Medworth Energy from Waste Combined Heat and Power Facility

PINS ref. EN010110
Document Reference: Vol 9.20
Revision: 7.0
Deadline 7
August 2023

Schedule of Changes (Deadline 7)

Key

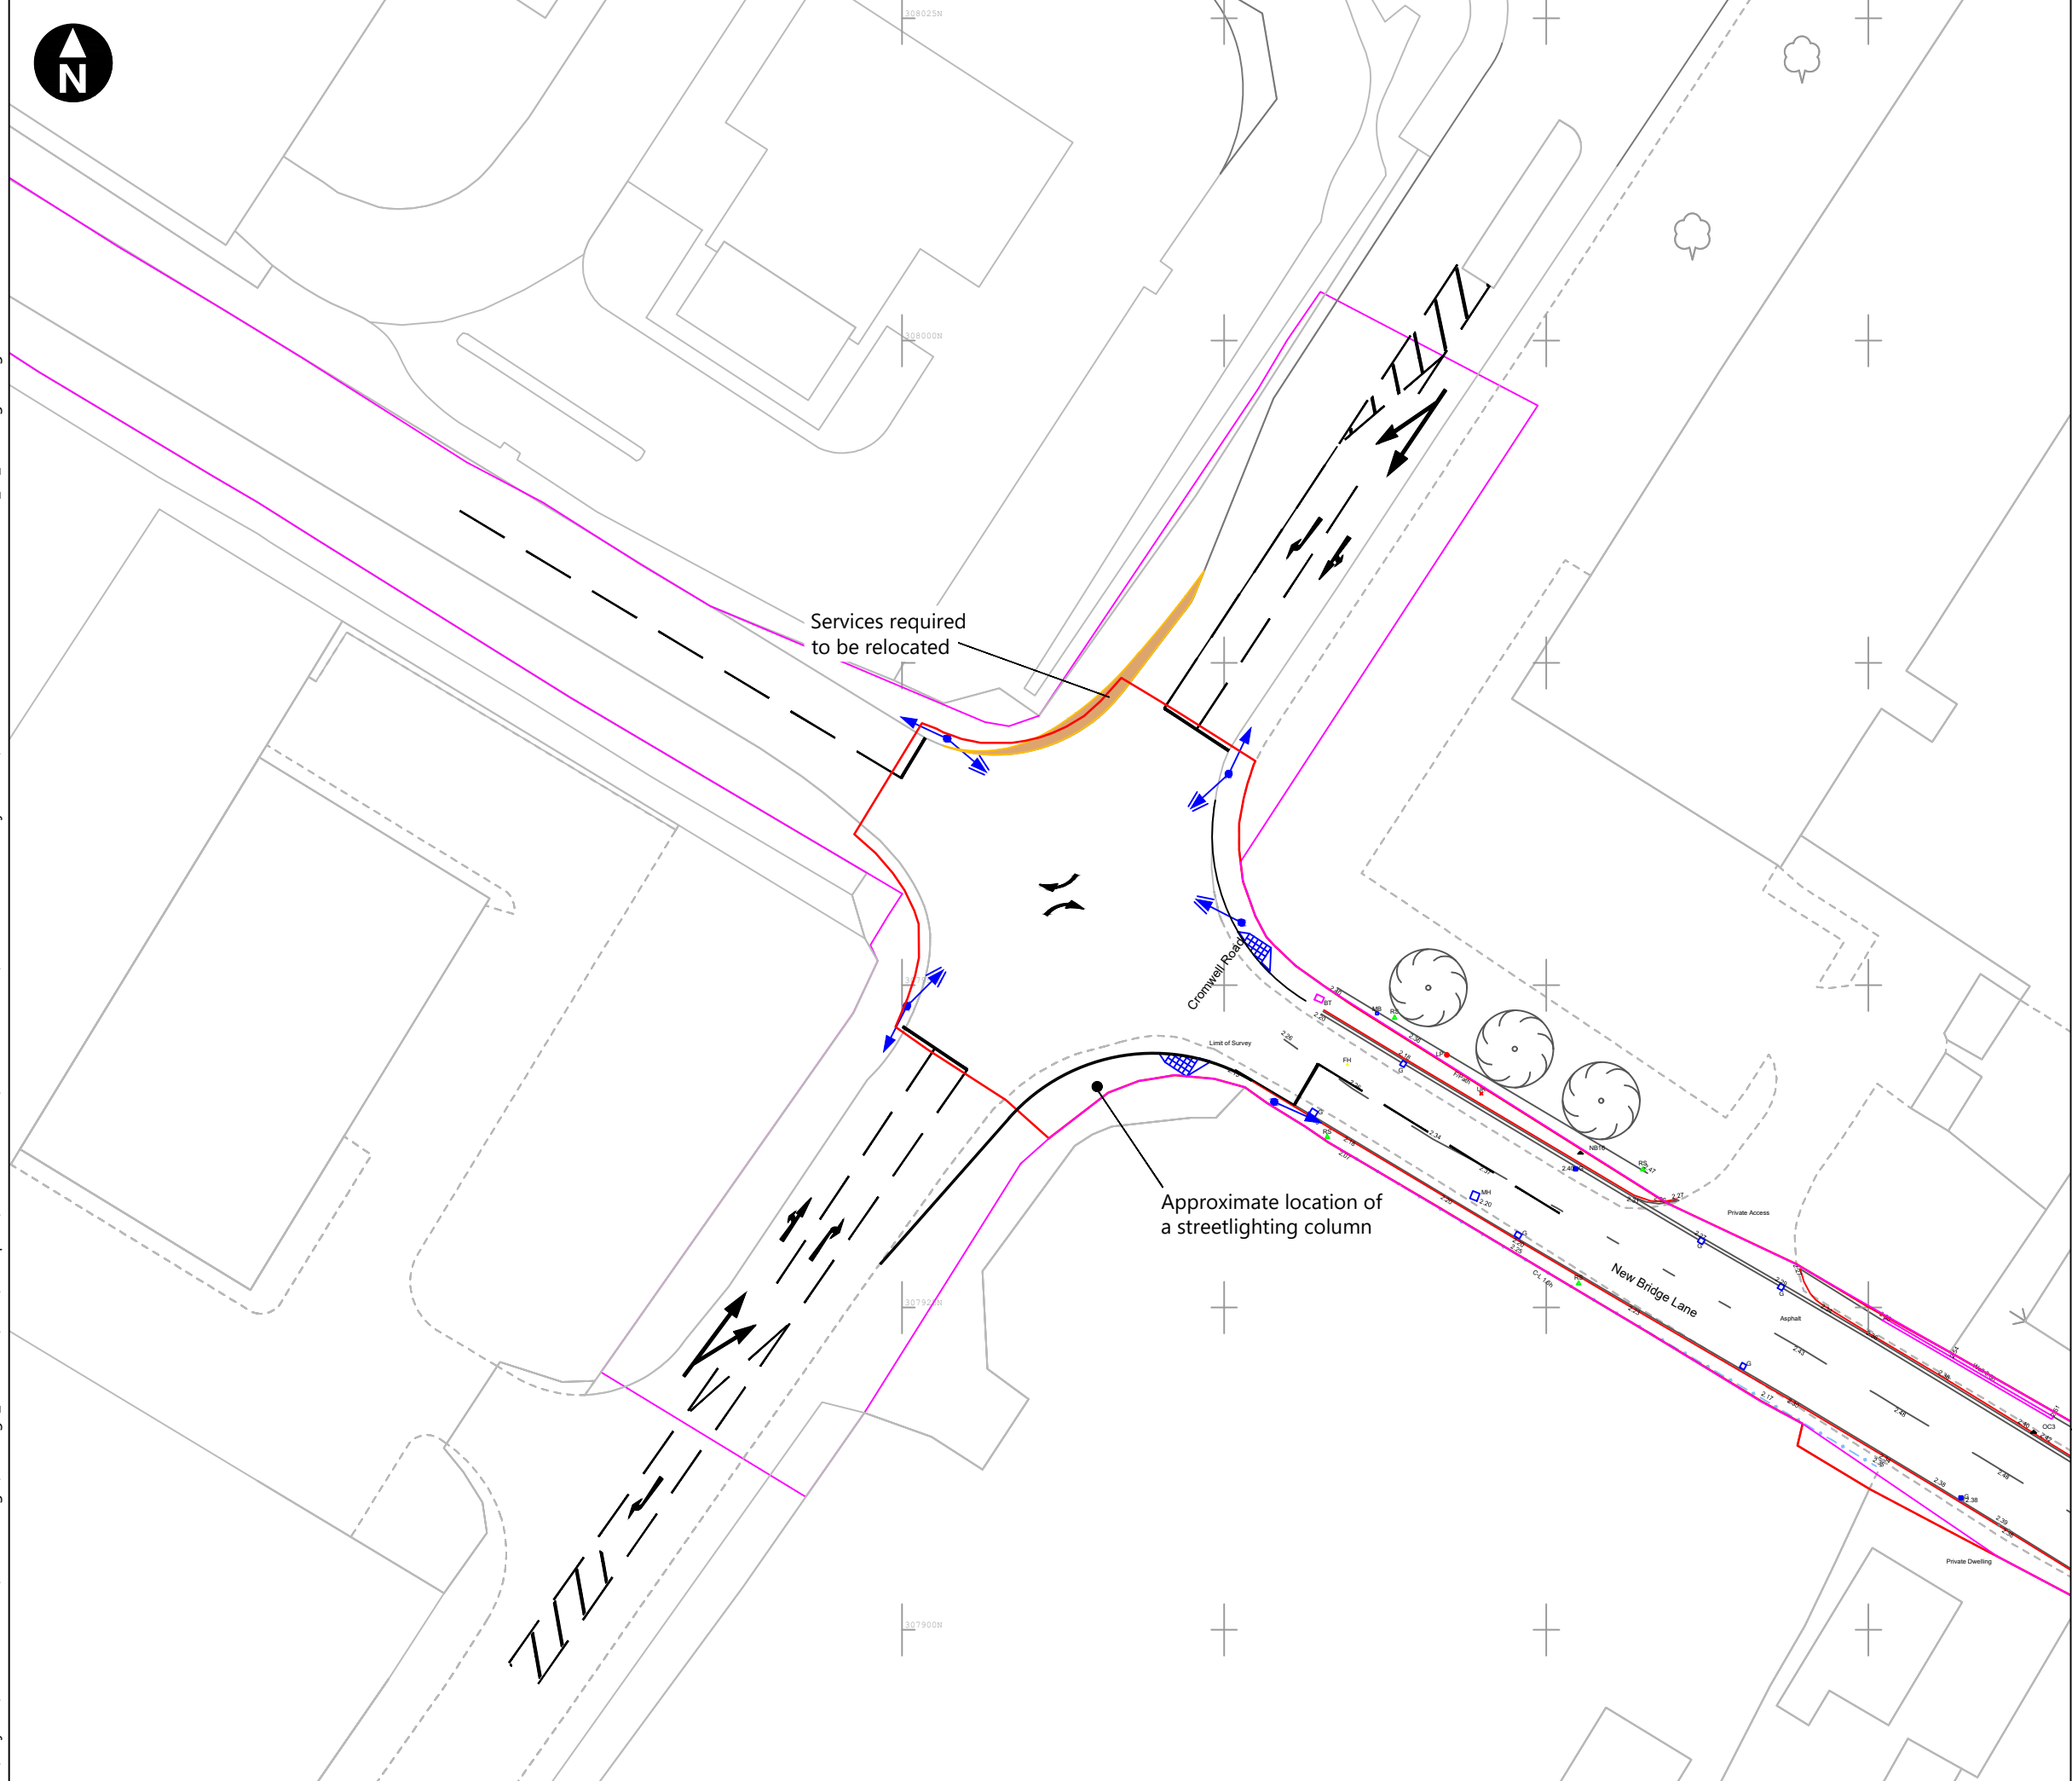
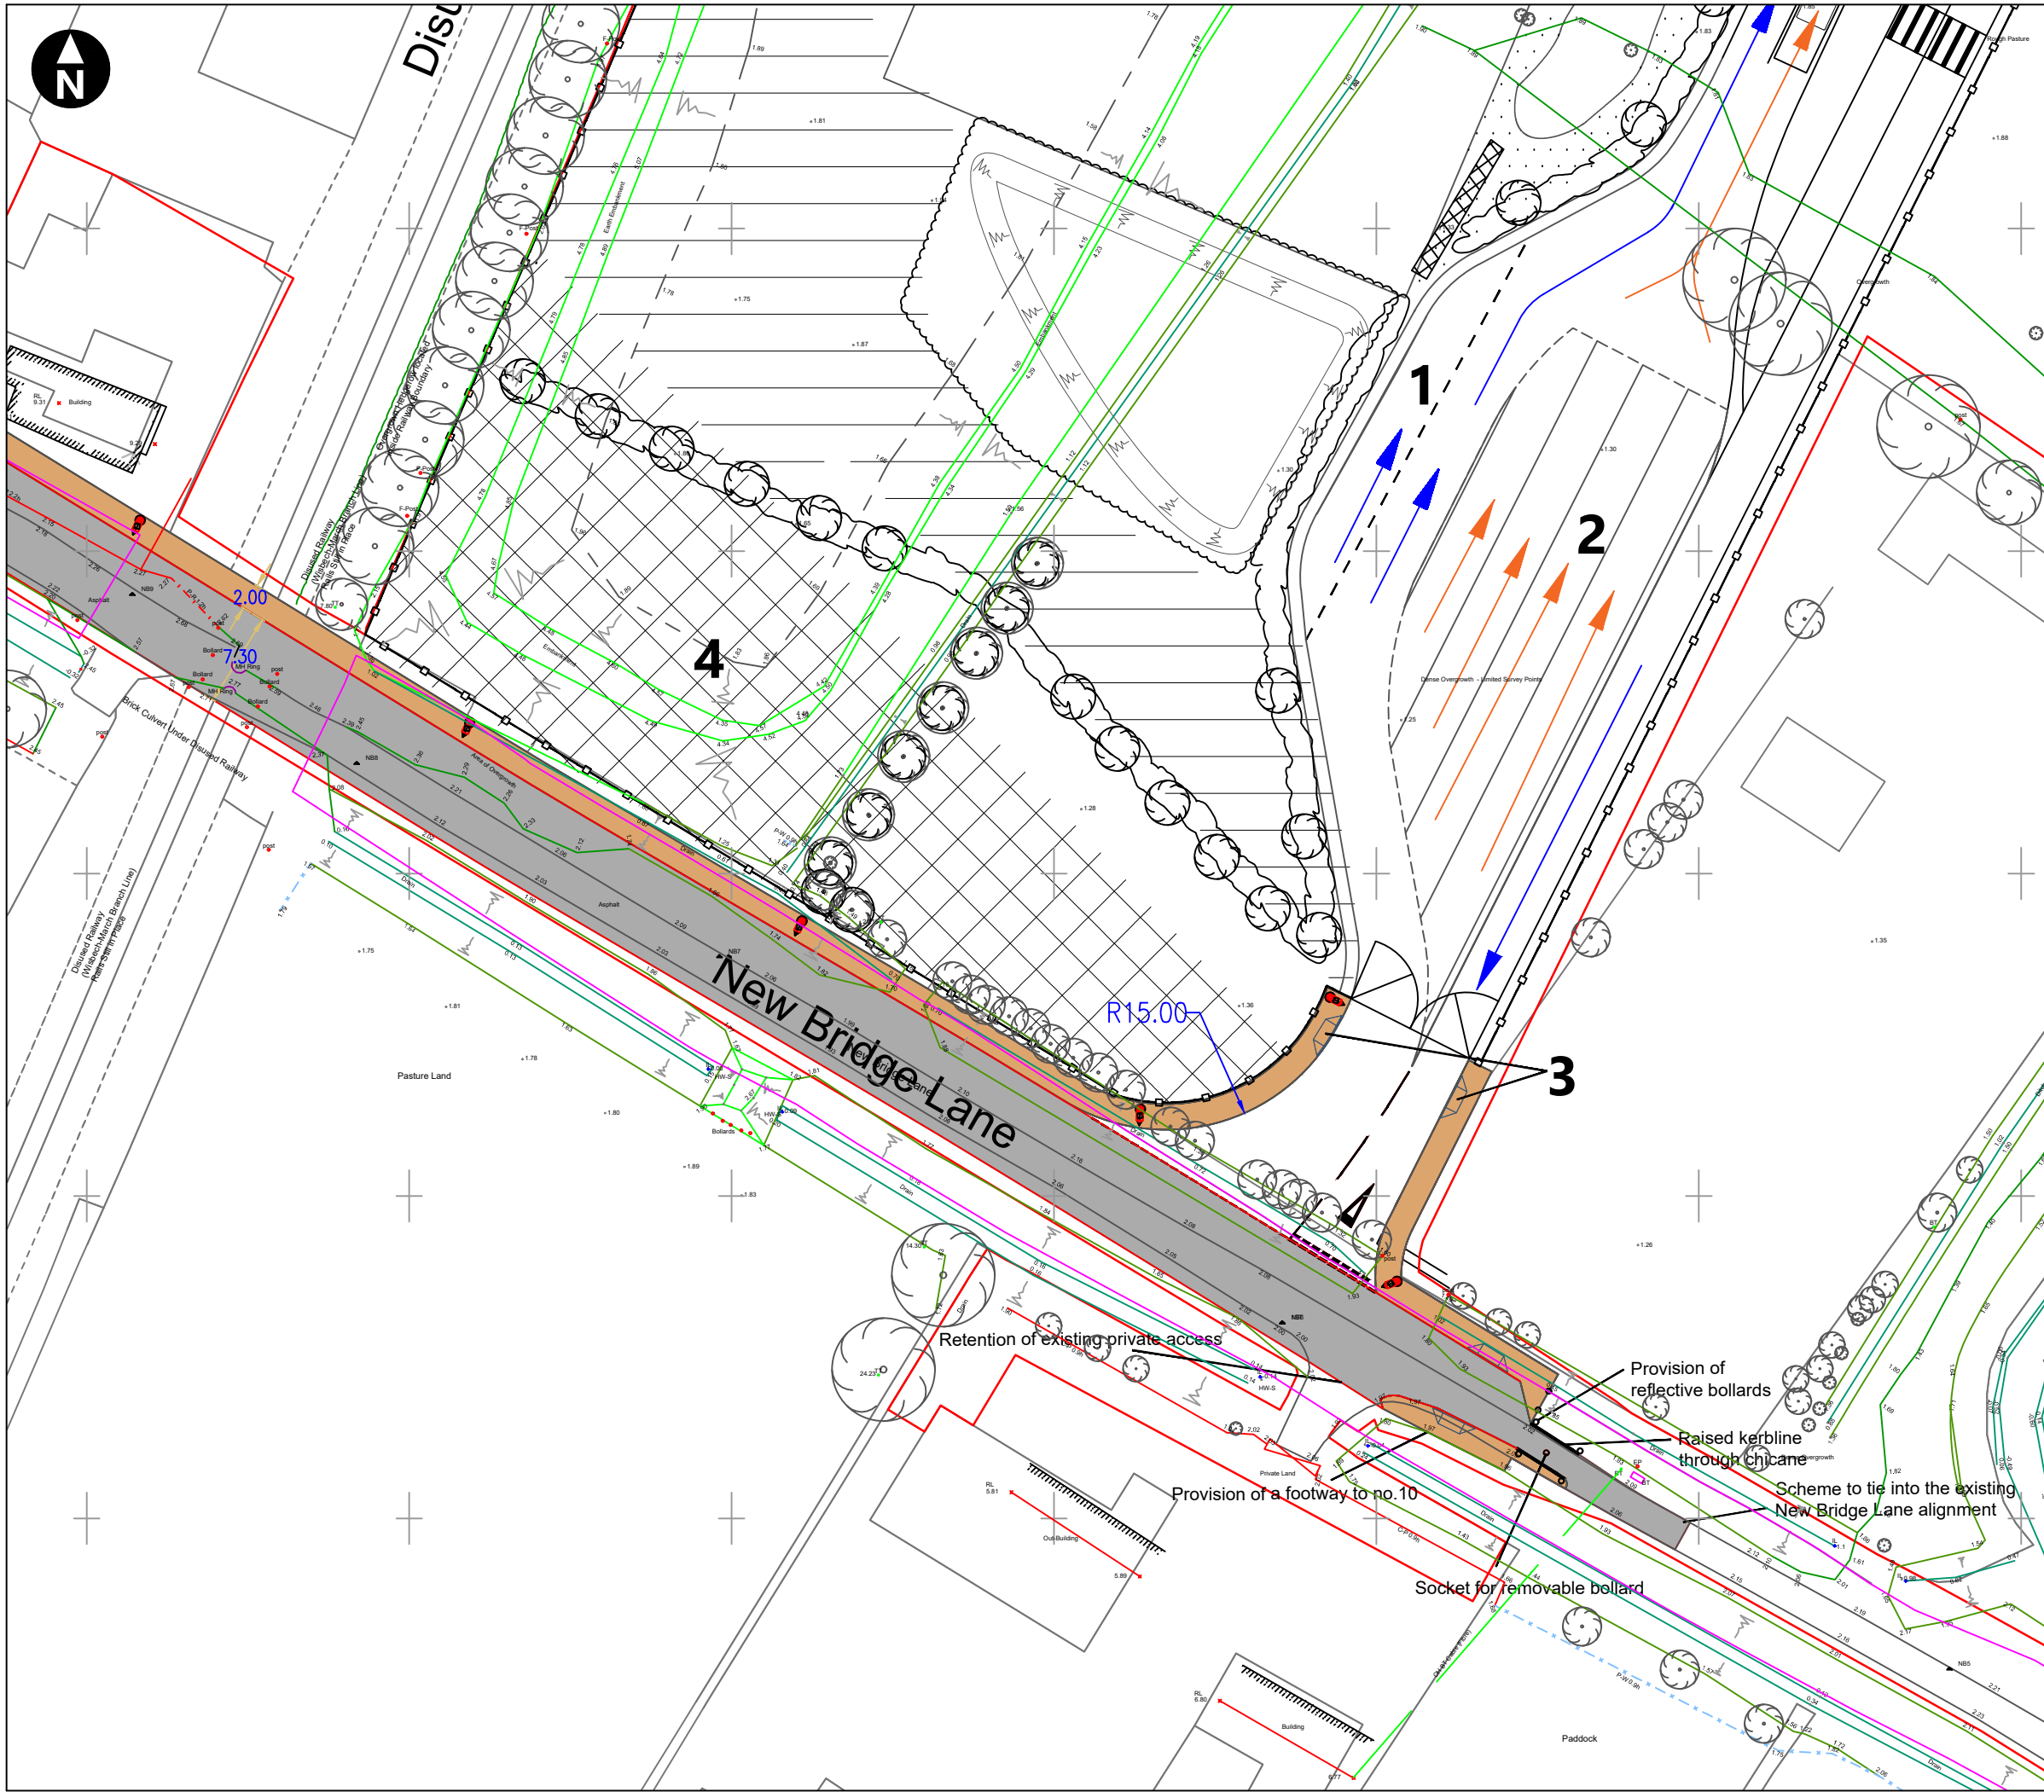
Volume 6.4 ES Chapter 6 Traffic	Additional drawings, Figures 9.2ii to show swept path of vehicle leaving New Bridge	CCC and FDC LIR paragraph 2.7.32 and 2.7.34 [REP1-074] .	Deadline 3	Rev 3

Document Updated	Change	Reason for change	Deadline submitted	Relevant Document version
and Transport Appendix 6A Outline (CTMP) [REP1-011]	Lane. Also Figure 10.3i – ii to show outline design for construction accesses into the CHP Connection Corridor from Weasenham Lane and accompanying swept path.			
Volume 6.4 ES Chapter 7 Noise and Vibration Appendix 7D Outline Operational NMP [REP1-012]	Reference to Applicant's intention to purchase 9 New Bridge Lane updated to confirm that the property has been purchased. Additional text added to 5.1.2 to include for the submission of a report to the relevant planning authority detailing the height, materials and acoustic performance of the acoustic fence to 10 New Bridge Lane for agreement ahead of construction.	CCC and FDC Comments on the Applicant's D1 Submissions (Outline CEMP) [REP2-031]. Outline Operational Noise Management Plan.	Deadline 3	Rev 3
Volume 6.4 ES Chapter 7 Noise and Vibration Appendix 7D Outline Operational NMP [REP1-012]	New paragraphs 1.4.8 and 1.4.9 to provide a commitment to the preparation of an Operational Noise and Vibration Management Plan for the Walsoken Substation.	KLWN Relevant Representation [REP2-028].	Deadline 3	Rev 3
